Item No. **Report of the Head of Development Management and Building Control**

Address: 71 HERCIES ROAD HILLINGDON

Development: Proposed extension to an existing vehicle access crossover.

LBH Ref Nos: 13487/APP/2024/3077

Scale 1:500 @ A4
Drawing No.: BP-01-2024
Sept 2024

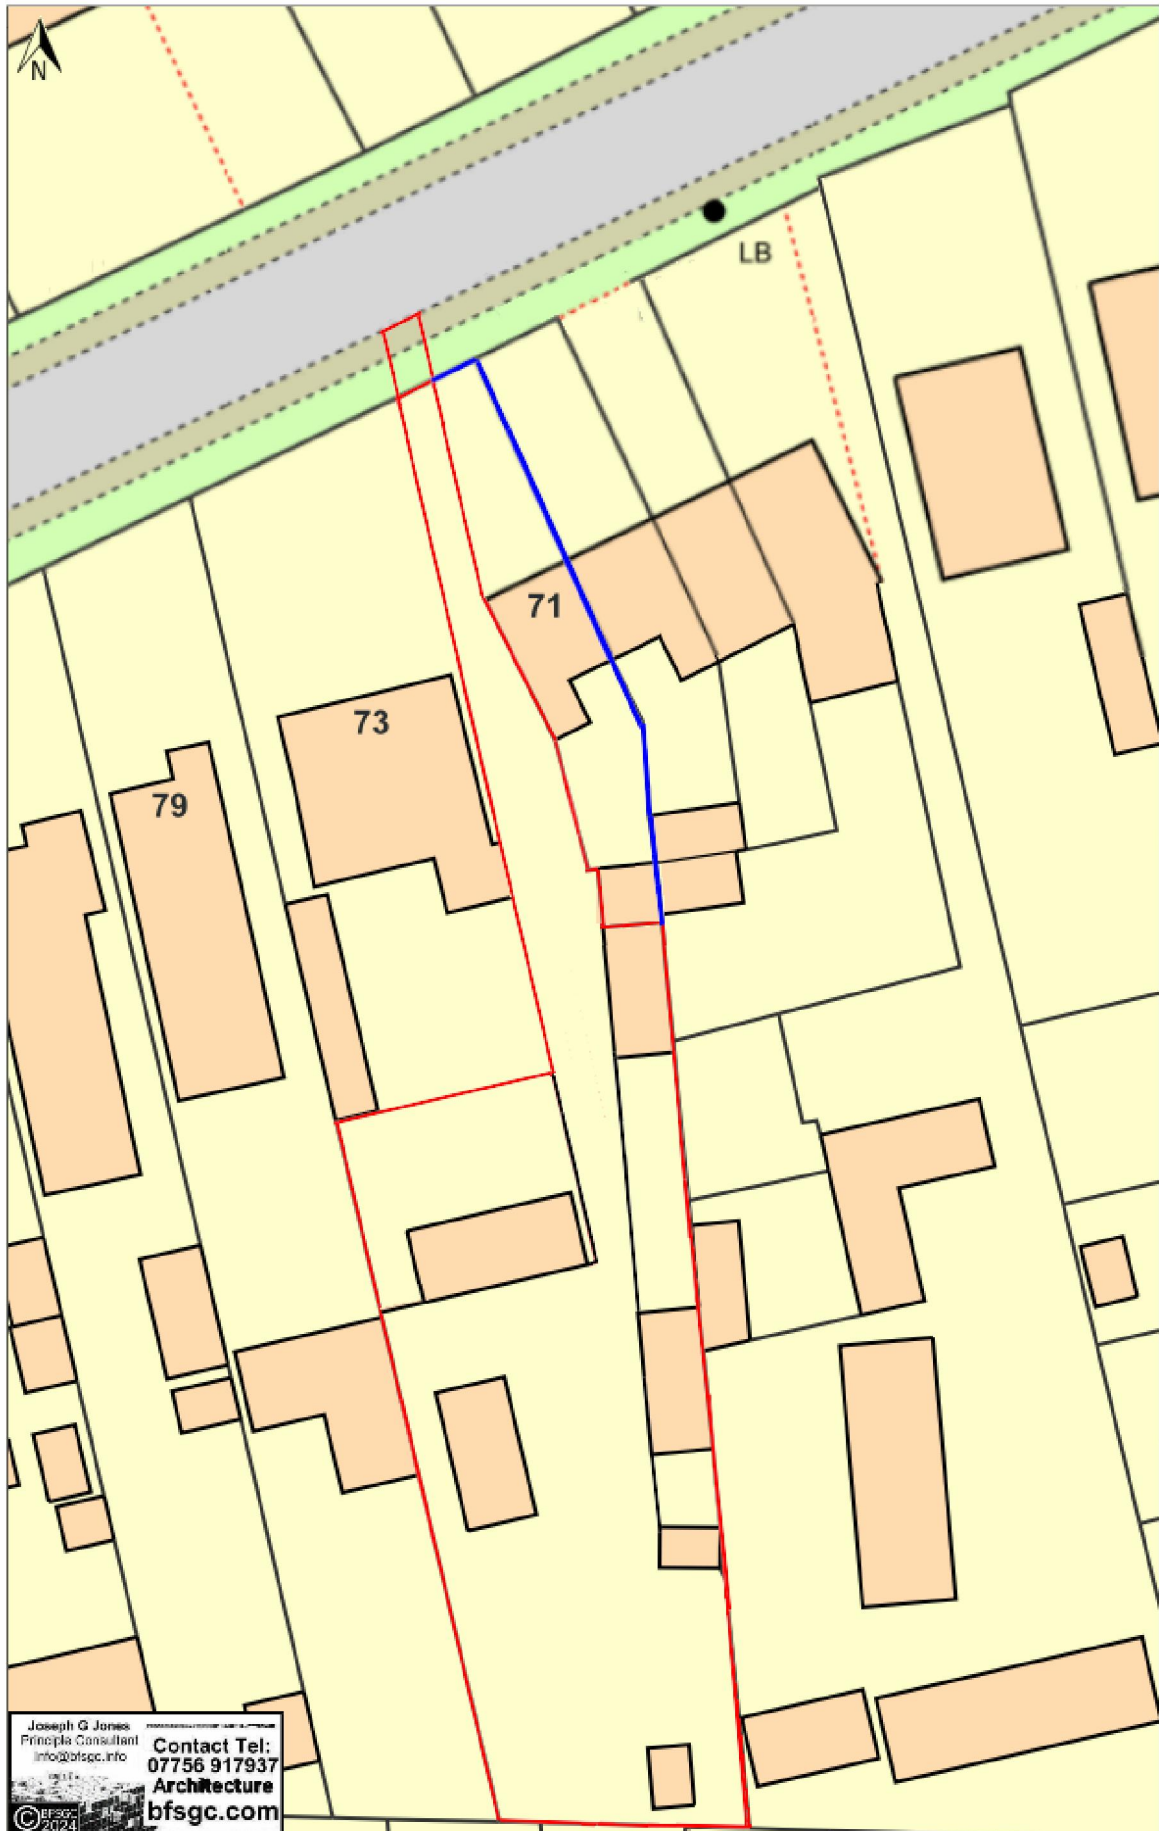
An application for planning permission has been received to extend the existing vehicle crossover at 71 Hercies Road. The road can be described as a local residential street. The drawing for the proposed extensions show that the site has a vehicle crossover of 8 metres and the proposal is to extend the crossover by 0.9 metres. Extending the crossover could compromise pedestrian safety as it would reducing the safe distance between pedestrians and vehicles accessing the site. The London Plan 2021, Policy T4 on Assessing and Mitigating Transport Impacts, mandates that development proposals should not exacerbate road danger. Furthermore, the Council's 2022 Domestic Vehicle Footway Crossover Policy stipulates that new crossovers cannot exceed 5 metres width. Consequently, the Highways Authority has objections to this proposal.

The Council's Highways Officer has objected to the development raising concerns about pedestrian safety, as it would reduce the safe distance between pedestrians and vehicles accessing the site. Additionally, the Council's 2022 Domestic Vehicle Footway Crossover Policy specifies that new crossovers must not exceed 5 meters in width. The proposal would therefore present unacceptable to pedestrian safety and the development would be contrary to Policy T4 of the London Plan (2021) and Local Plan Part 2 Policies DMT 2, DMT 5 and DMHB 12 and is therefore recommended for refusal.

Due to its width, dimensions and location, the proposed extension to the vehicle crossing would significantly compromise the safety of pedestrians and cyclists contrary to Policies DMT 2, DMT 5 and DMHB 12 of the Hillingdon Local Plan: Part 2 - Development Management Policies (2020), Policy T4 of the London Plan (2021), and the Council's 2022 Domestic Vehicle Footway Crossover Policy.
